**PLANNING ACT 2008
APPLICATION BY HIGHWAYS ENGLAND FOR AN ORDER GRANTING
DEVELOPMENT CONSENT FOR THE A303 SPARKFORD TO ILCHESTER
DUALLING
SUBMISSION MADE PURSUANT TO DEADLINE 6**

PLANNING INSPECTORATE REFERENCE TR010036

SUBMISSION MADE PURSUANT TO DEADLINE 6a

Somerset County Council Response to Deadline 6a: - The Examining Authority's written questions and requests for information (ExQ3) Issued on 25 April 2019

Location

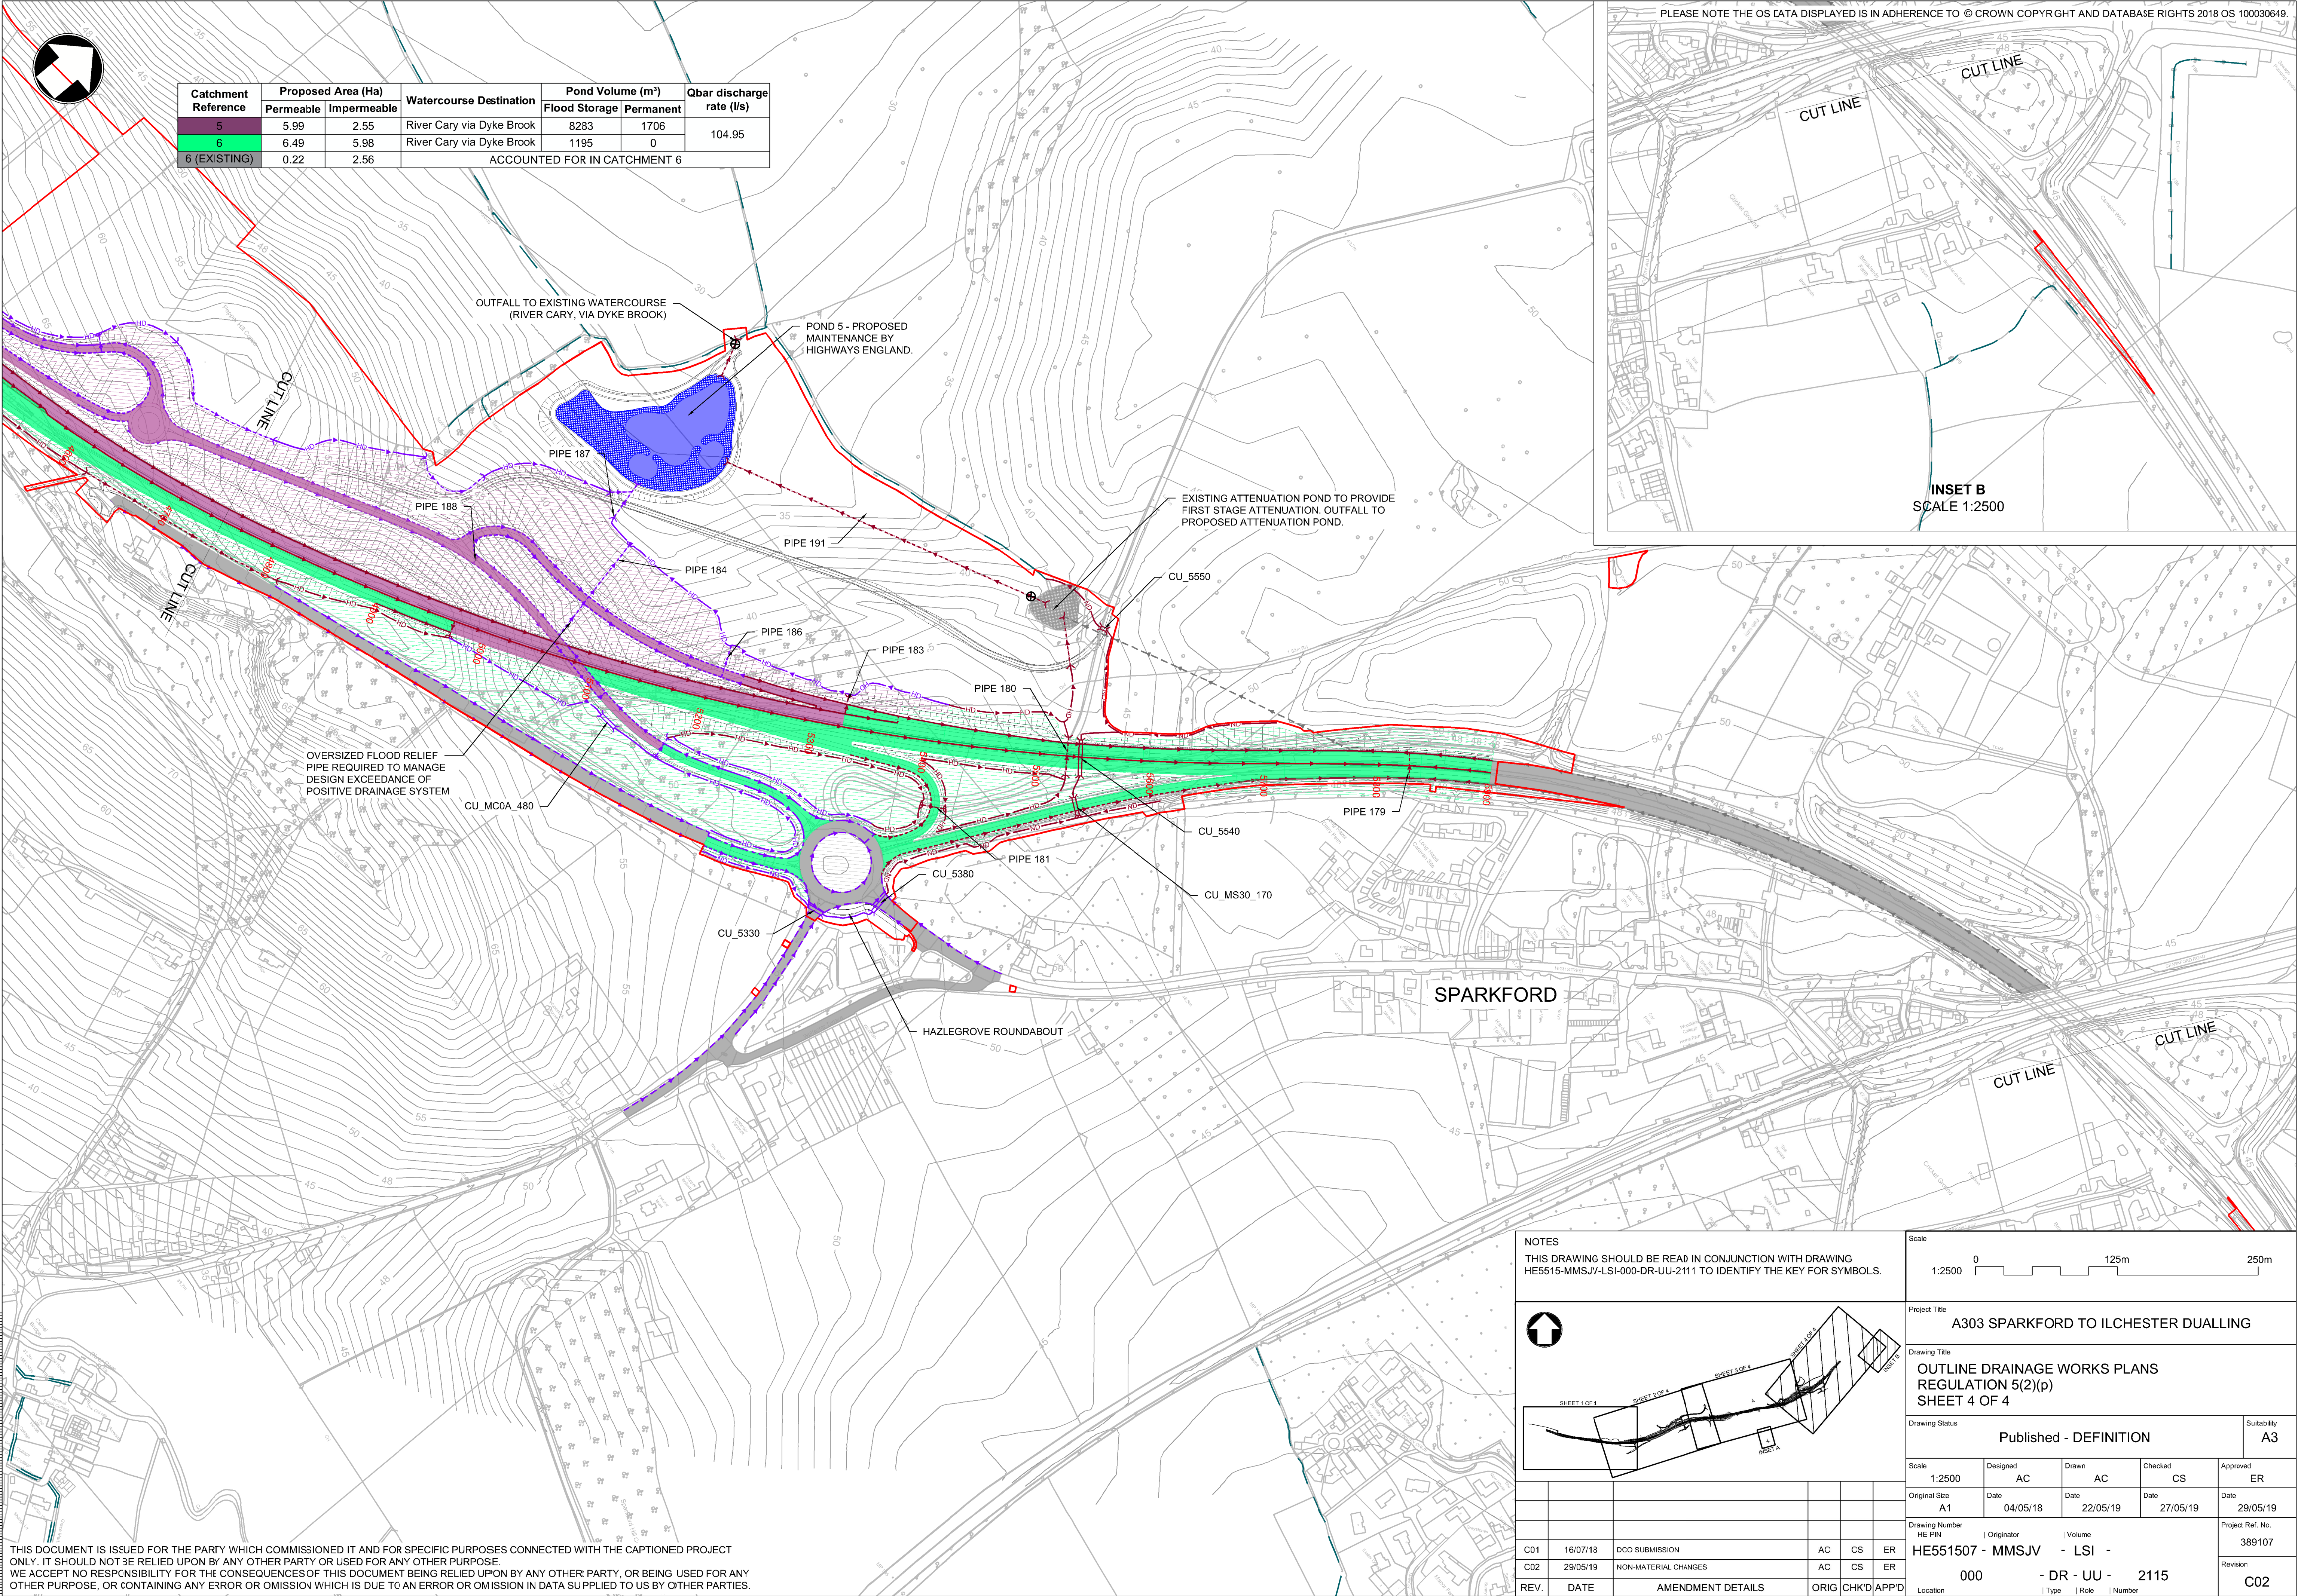
3.10.17	<p>Schedule 2 - Requirement 13 Surface Water Drainage</p> <p>While the dDCO limits the relevant discharge rates, it does not provide for the maintenance of the Sustainable Drainage Systems (SuDS) schemes. Therefore, it could</p>	a) SCC agrees that a maintenance regime would need to be secured. Appendix 4.7 (Drainage Strategy Report) of the Environmental Statement dated July 2018 does set out an indicative maintenance regime within Tables 7.1;

ExA Q Ref	Question	SCC Response
	<p>lead to excessive water retention on the site with unassessed effects. By ensuring that the SuDS schemes are managed and maintained this avoids this issue.</p> <p>a) Therefore, is a scheme for the management including maintenance of the SuDS schemes to ensure long-term effective operation required?</p> <p>b) Should be this scheme for the approval of the Local Lead Flood Authority as this this is the statutory authority and thus would be the appropriate level for authorisation?</p>	<p>Table 7.2; and Table 7.3. However, it's not clear how maintenance is then actually secured within the DCO.</p> <p>When being consulted on Town and Country Planning Act applications, SCC as the Lead Local Flood Authority will seek individual planning conditions to secure the submission, approval and implementation of maintenance arrangements, where relevant. SCC will be able to provide draft wording at the relevant Issue Specific Hearing.</p> <p>b) SCC advises that the scheme is submitted to the Local Planning Authority for approval in consultation with the Lead Local Flood Authority.</p>
